AUTUMN ACRES

PHASE 1 PLAN REVISION 1 MARCH 2022

V1_Sketch Plan Drawings.pdf Markup Summary 2-22-2023

ZONING MAP

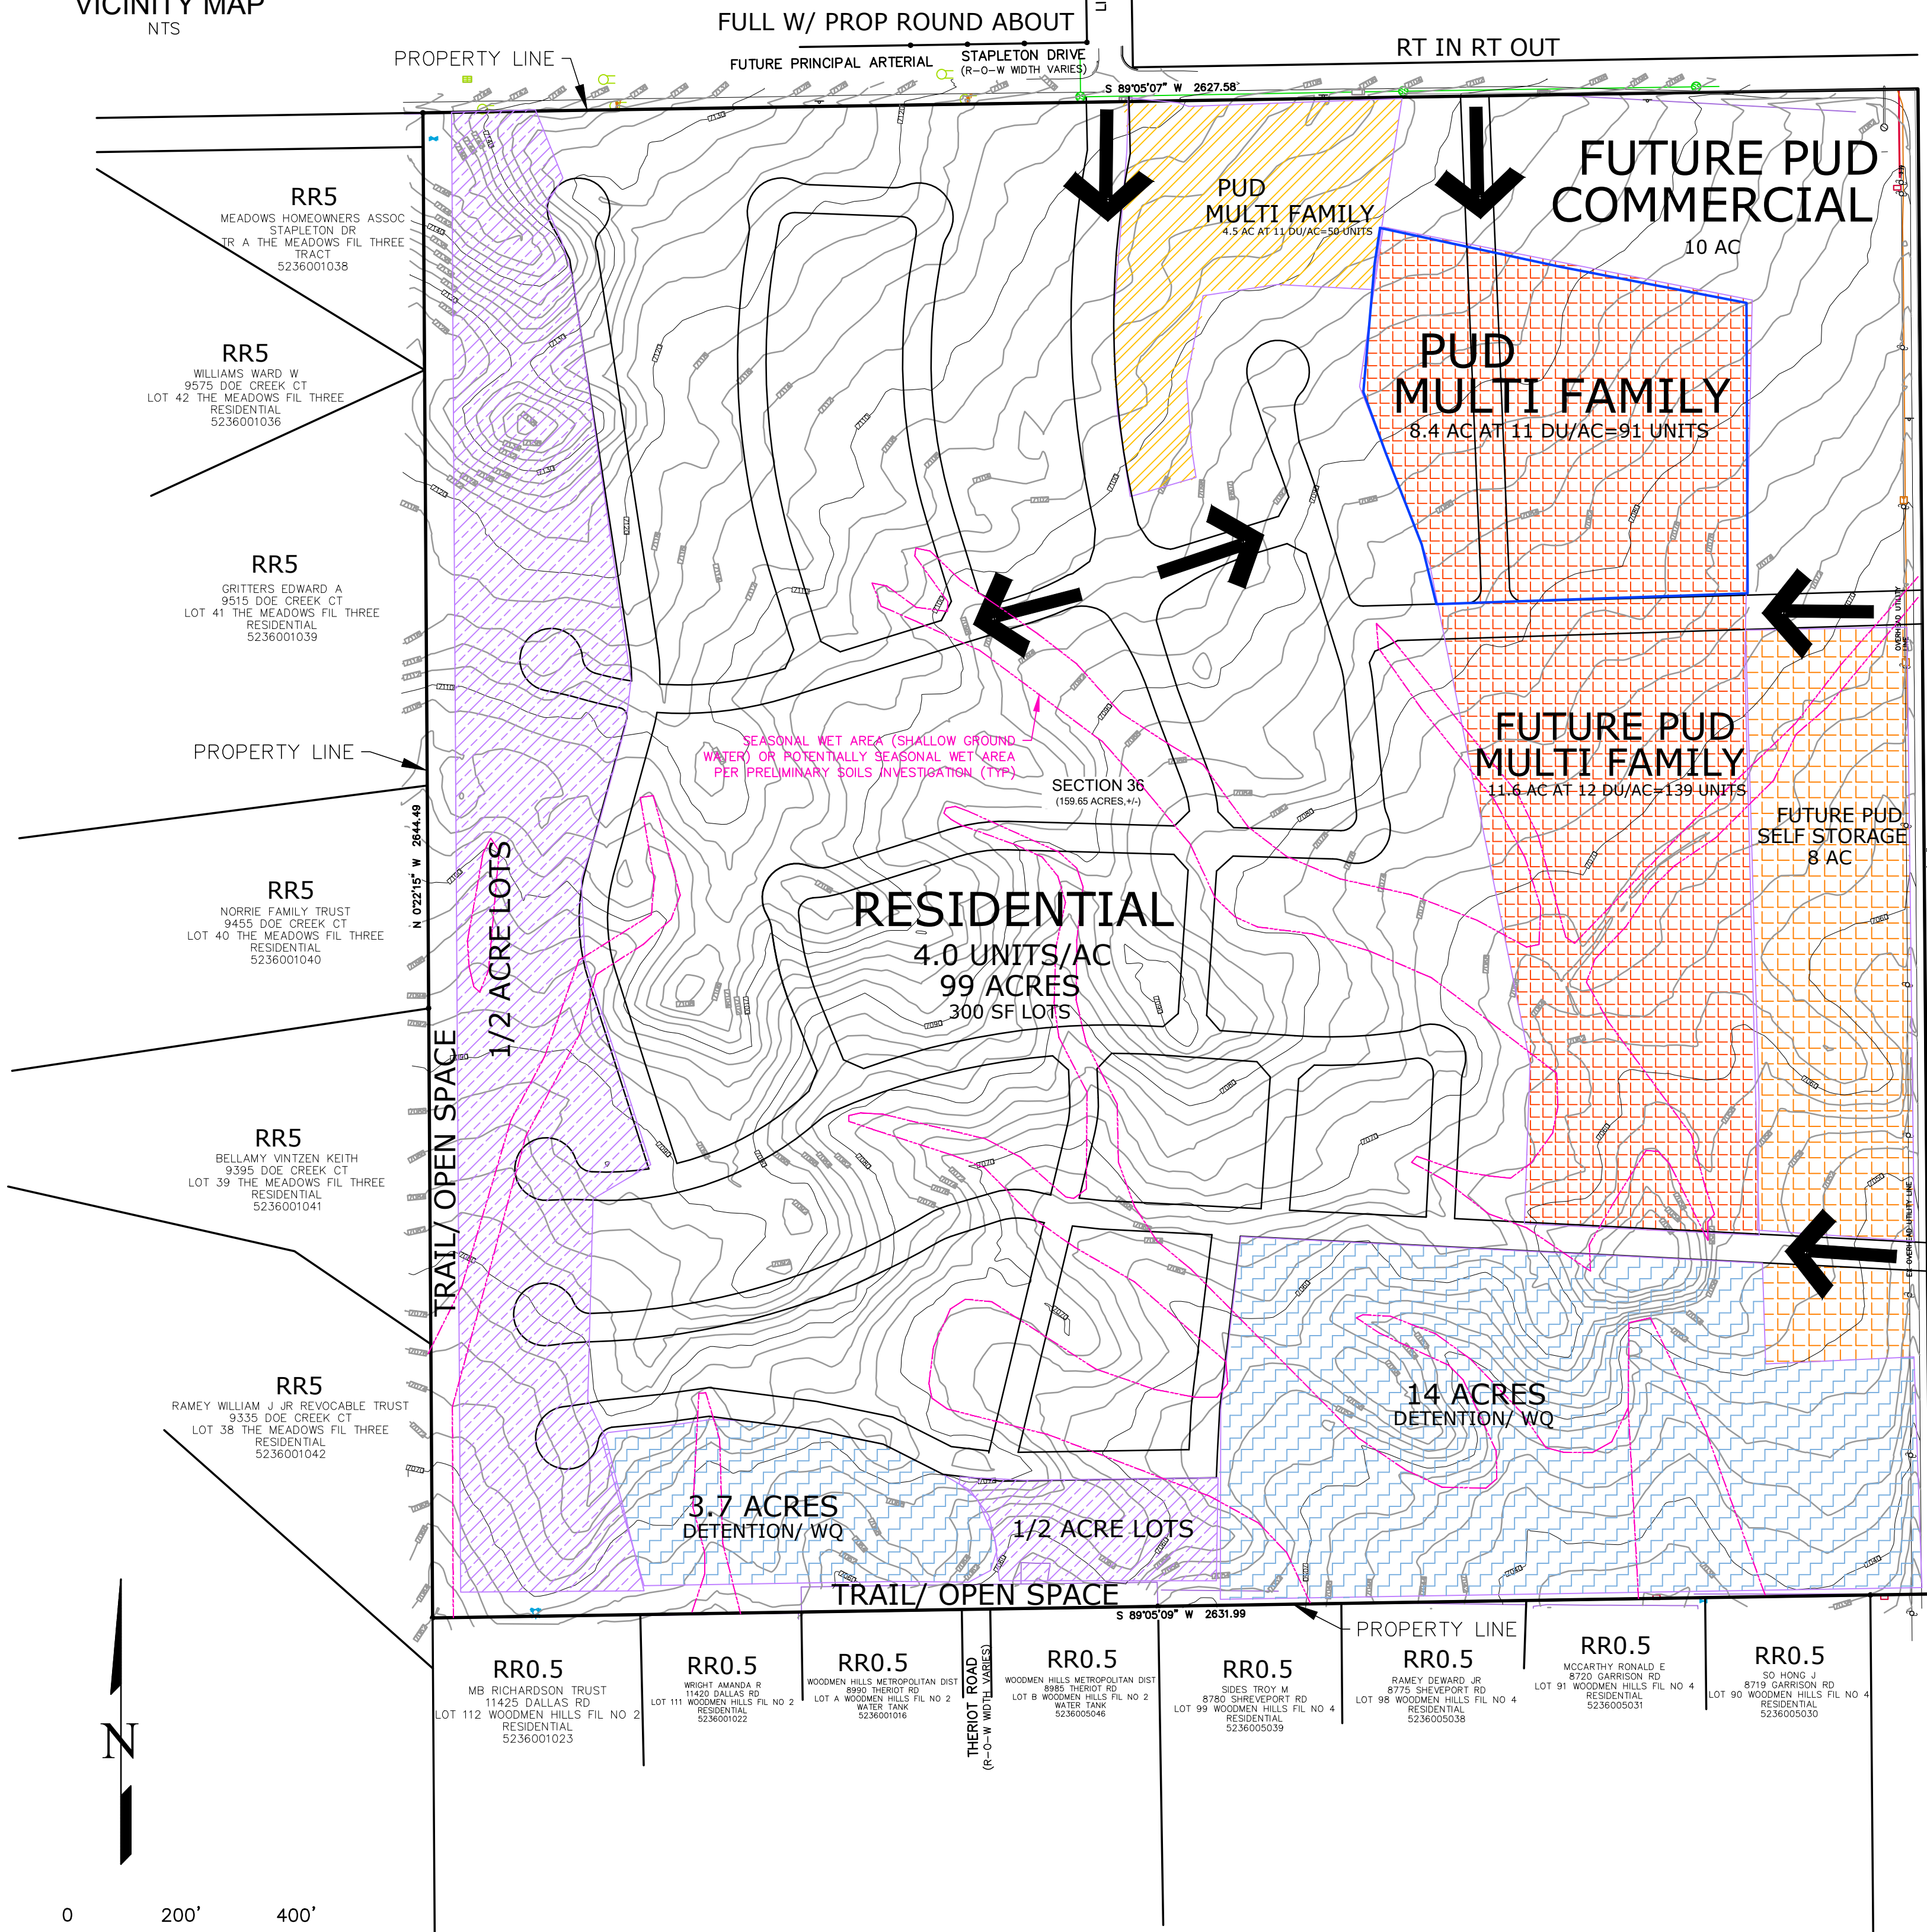
Identify proposed ROW dedication along Stapleton. The current Stapleton corridor plan that is currently in progress identifies a 168' ROW width for Stapleton.

Depict the utility landuse area for the Sanitary lift station and other components.

Provide a deviation request for intersection spacing as a principal arterial requires 1/2 mile spacing.
Add a general note that the full movement access will change to a RIRO with future widening of Stapleton Road in accordance with the Stapleton-Briargate corridor access control plan.

identify as full access in instead roundabout

As noted during the early assistance meeting this access does not meet intersection spacing criteria and will not be approved. Remove proposed access location.

landscape setback required along major arterials outside of dedicated row- depict as buffer /landscape setback

Existing Meridian Road is currently within the property. Provide additional ROW per the Meridian North Corridor Plan. See area highlighted in yellow for additional ROW.
Control Plan study is available at <https://publicworks.elpasoco.com/road-bridge-planning/>

depict trails per 2023 Parks Master Plan

Show the existing ROW along the east side of Meridian Road.

only show the collector roads and arterials; w access points at key intersections; a sketch plan does not set roads. Please, remove local roadways; remove the zoning from the plan and identify density and landuse, transitions, buffers etc. Please look at SKP 223, SKP224; SKP 225; SKP201; for examples of what is to be depicted and typical notes. A phasing plan can be eliminated if notes are depicted on SKP that anticipated phasing is XYZ; subject to change without a skp amendment being required

depict roadway line work for Meridian and Stapleton. Identify any dedication that will occur based on TIS

As noted during the early assistance meeting this access does not meet intersection spacing criteria and will not be approved. Remove proposed access location.

Clearly delineate bubbles for density and land use.

Add note that states that the proposed streets and access locations are conceptual and subject to change. Deviation requests must be approved for transportation and access design that is not in conformance with the EPC Engineering Criteria Manual Standards.

remove future or proposed- this is a sketch plan which is setting the future, key access points, density and land use categories

remove the self storage label and put commercial;

this area should be depicted as open space as its not suitable for LOT MIX structures

Please set up a legend to show trails, open space, ponds, density various landuse categories etc as istypical on SKP submitted

dimension buffers

See Engineering Criteria Manual (ECM) chapter 2 for roadway design criteria. Maximum cul-de-sac length is 750 ft for urban condition.

place the areas to be preserved in open space- this would cause significant concern with Criteria for approval depicting much of the site w water shallow- decide what areas will be preserved.

Show and Identify access to Theriot Road

Is there a residential unit density cap based on water? what is the cap square footage on commercial?

Depict there trail connectivity throughout the site (use notes to state internal sidewalks will connect the trails shown) please

Please categorize and match the Code definitions and use tables; Single-family attached, single family detached, commercial; multi-dwelling etc- see checklist

The TIS noted 9,760 average daily trips (ADT) are generated by the development. This exceeds the design ADT for urban local roads. An internal collector spine road is likely required from the access on Stapleton to the access on Meridian Road and shall be shown and labeled on the plans.
